Subject: RE: LU/369/21/RES Central Wetland Area

Having received comments and advice from our external consultants, I do not believe that we (Engineers) have any aspects of the Application for the Central Wetlands (LU/369/21/RES) that would preclude discharge.

CROSS SECTION OF FOOTBRIDGE
Scale= 1:50

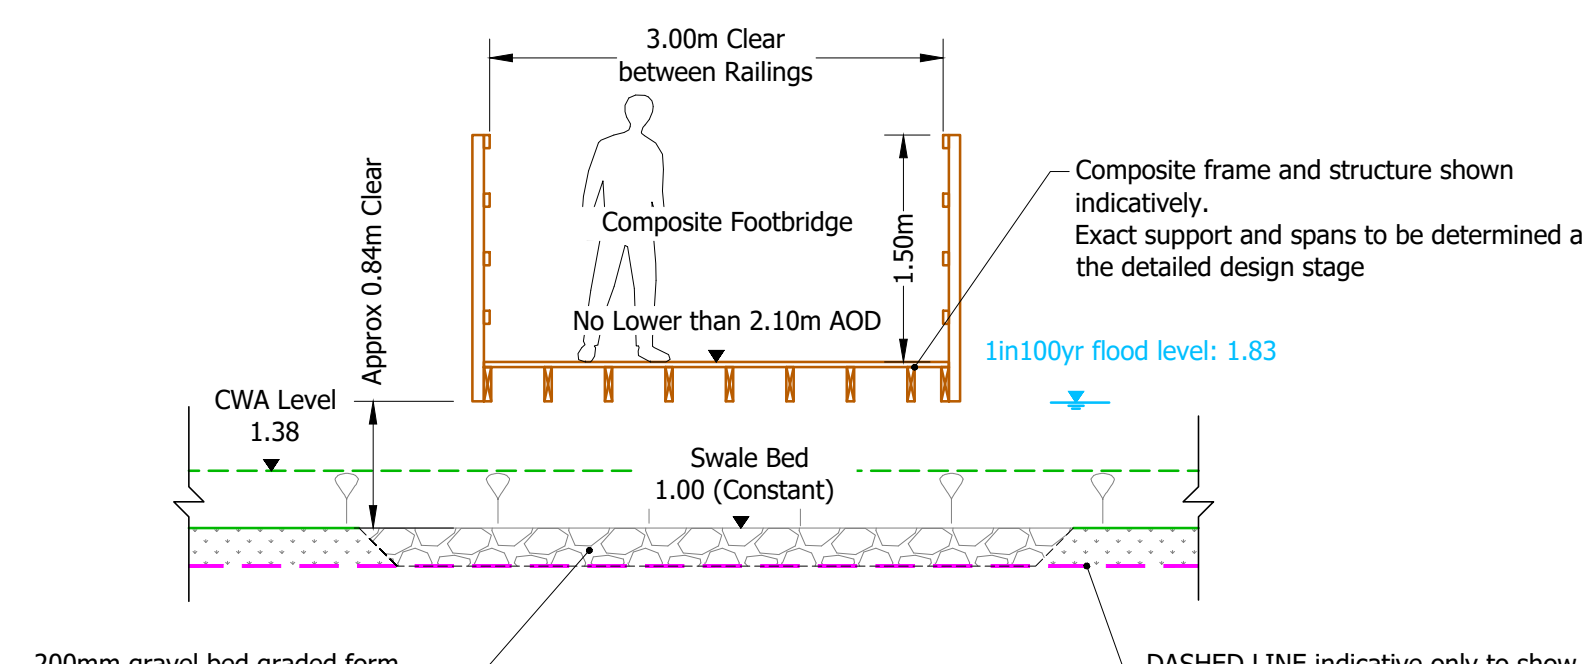
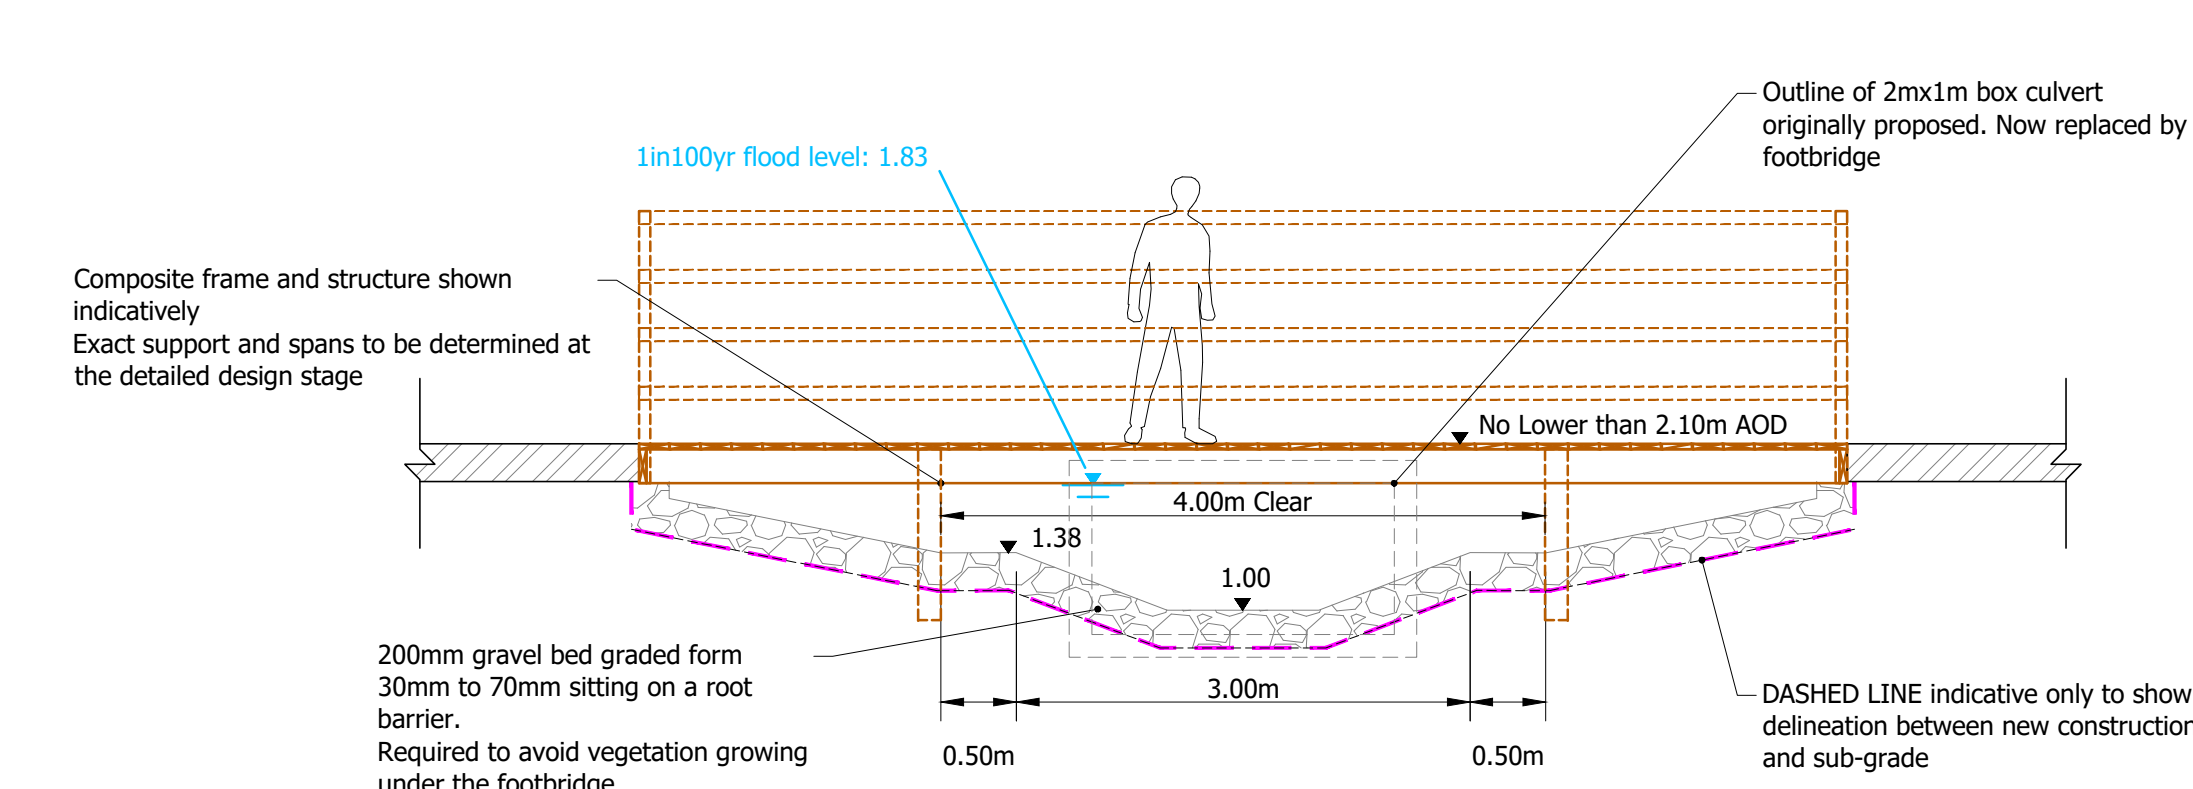
The external consultants raised a few issues for consideration at DOC stage, particularly the ability of the boardwalk to allow sufficiently free flow in and out of the wetlands and to ensure that the flood levels within the wetlands will be taken account of in the calculations for Ph 5 (ie submerged or partially submerged outfalls).
